RE: **McMahon Carwash**
McMahon and Fineland NW
Grading Plan Stamp Date: 8/17/18
Drainage Report Stamp Date: 8/17/18
Hydrology File: A11D016A

Based on the submittal received 8/13/18 and updated information provided on 8/17/18, the Grading Plan and Drainage Report are approved for Preliminary Plat and Building Permit.

RE: **McMahon Carwash**
McMahon and Fineland NW
Grading Plan Stamp Date: 6/20/18
Drainage Plan Stamp Date: 6/20/18
Hydrology File: A11D016A

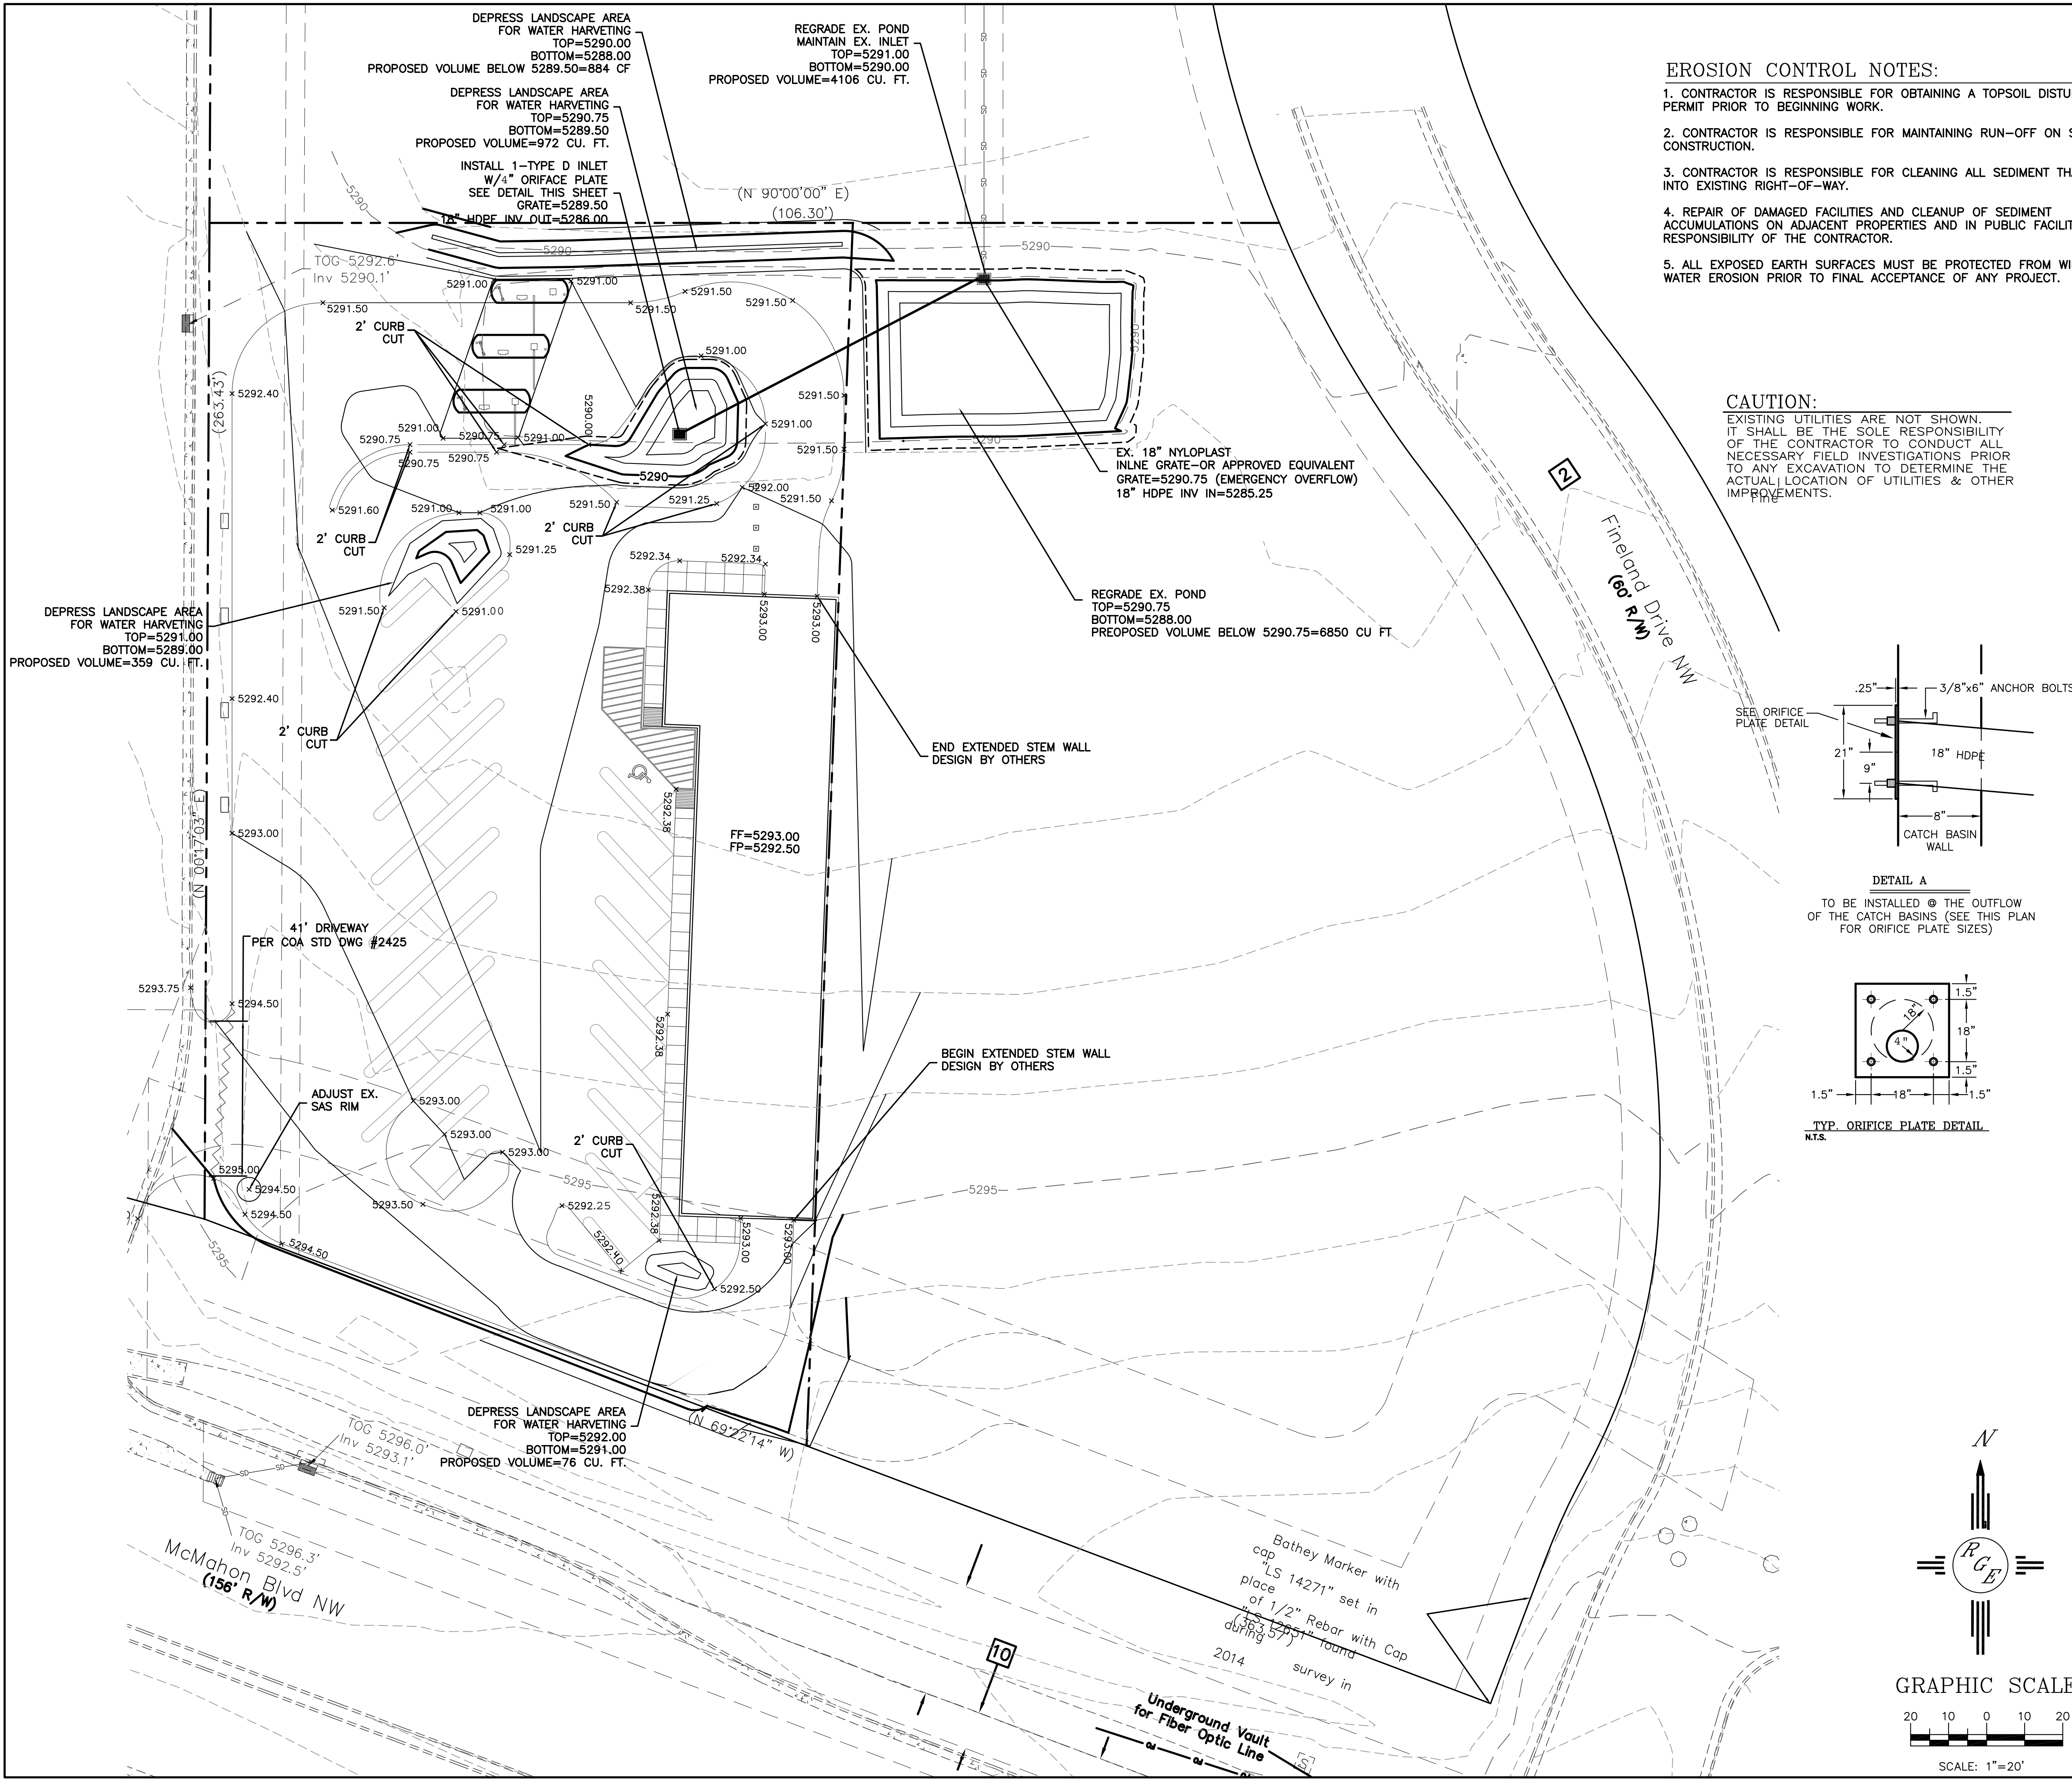
1. The first flush retention areas need to be clarified. The 4 small ponds in West Basin do not adequately capture the required volume. The north pond is higher than the parking lot and nothing seems to drain to it. The center pond has the grate elevation set at the bottom of the pond, so no dead storage is provided. The area draining to the 2 south ponds needs to be quantified, and the ponds sized to retain this first flush volume. **WE HAVE UPDATED POND TO CAPTURE FIRST FLUSH**

2. Provide minor contour labels and define spot elevations (top of curb, flowline, etc...). The spot elevations don't appear to agree with the proposed contours and it is difficult to see where the emergency overflows will go if the orifice plate clogs. **WE HAVE CORRECTED CONTOURS AND ADDED LABELS**

3. The elevations used in the volume calculations and orifice plate sizing (appendix B) do not match those on the grading plan. Please correct and show the max water surface elevation on the grading plan. **WE HAVE CORRECTED AND SHOWN MSWEL**
